Reference: SC639

19 September 2022

**Re: Application SSI-9406 – Inland Rail – Illabo to Stockinbingal**

8.1 Overview of proposal construction

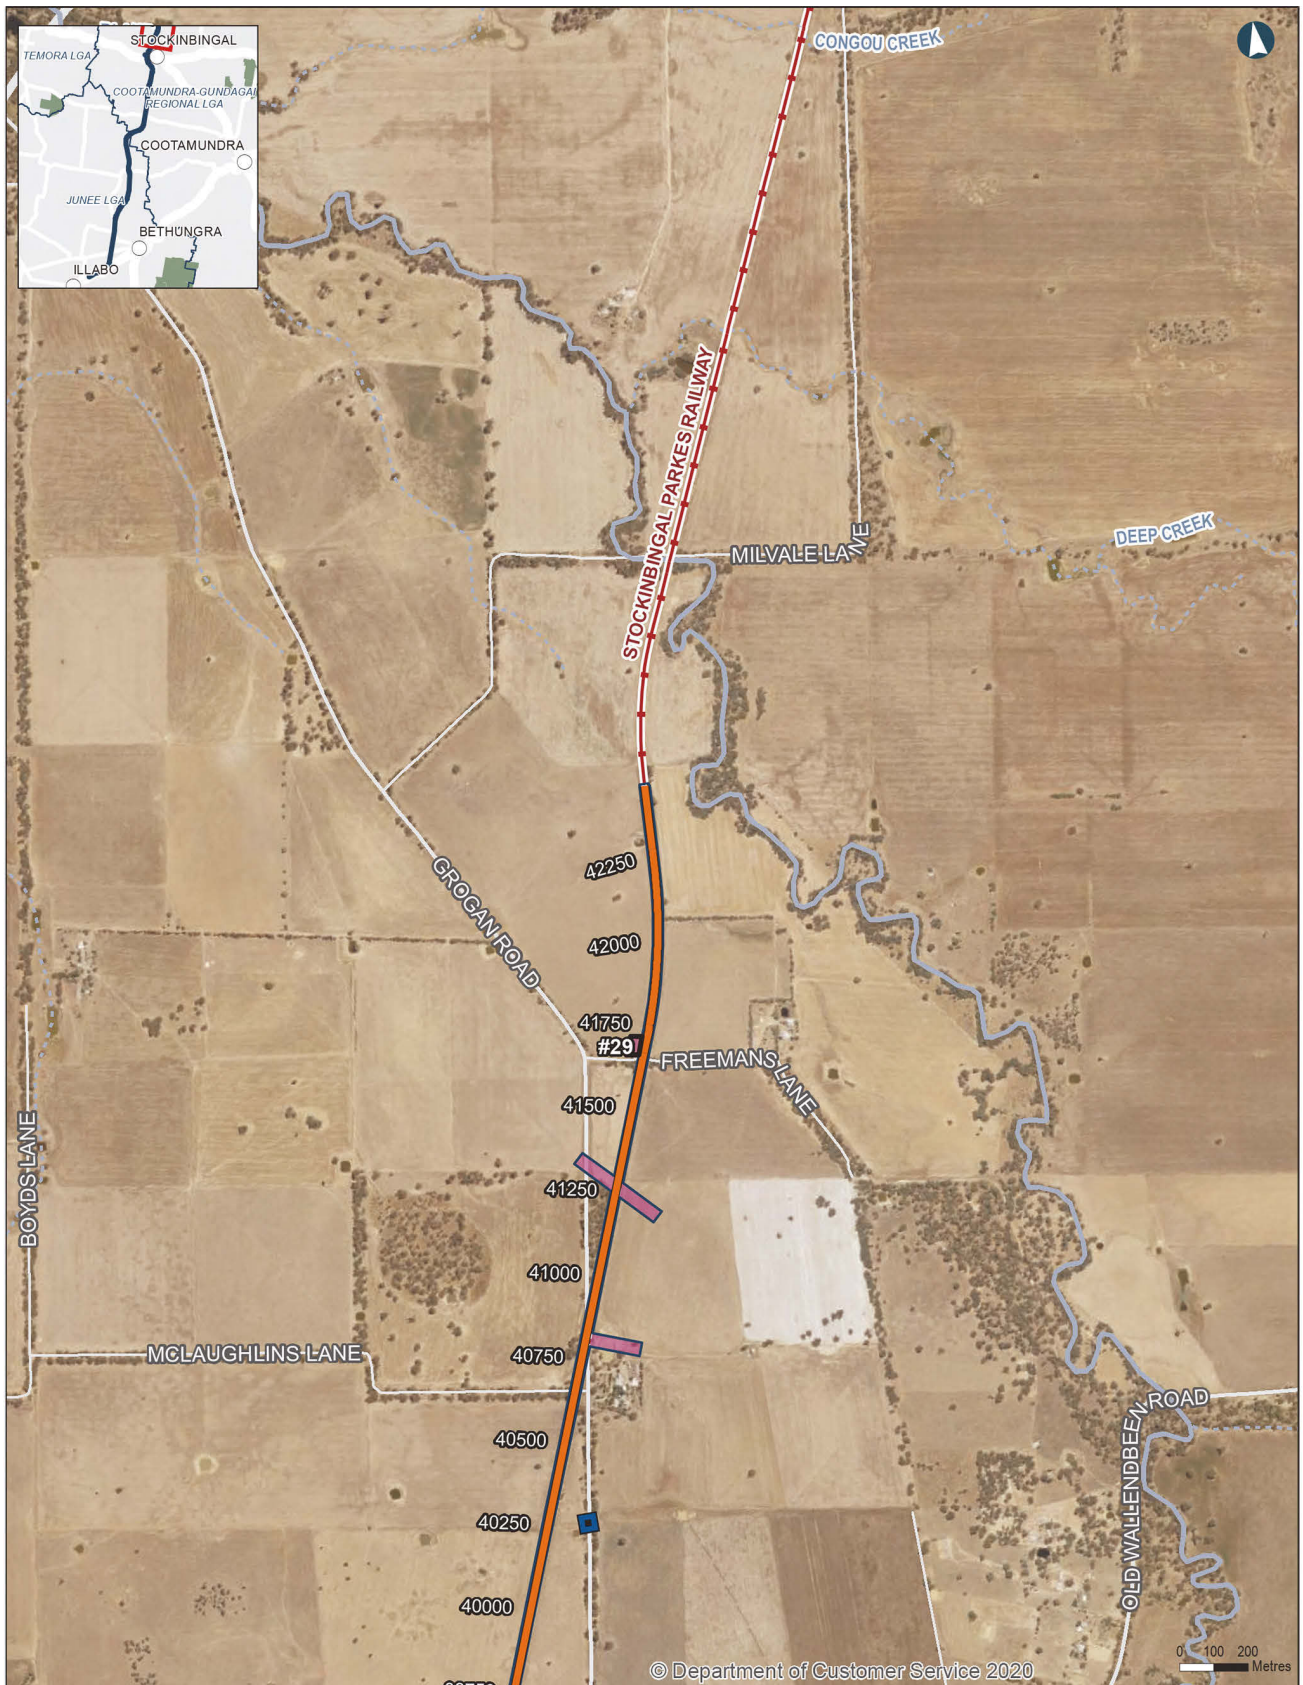
The potable water reservoir is critical infrastructure for the village of Stockinbingal. It is noted that the NBN Tower is to be relocated (Figure 8-1, Map 9), which is located directly adjacent to the reservoir, yet no protection of the reservoir has been considered by the proponent. GWCC believes that the proposed design and construction methodology will significantly impact this critical asset and water supply for the township of Stockinbingal and an alternative measure needs to be accommodated prior to any construction phase. This could require the relocation and an augmented water supply network.
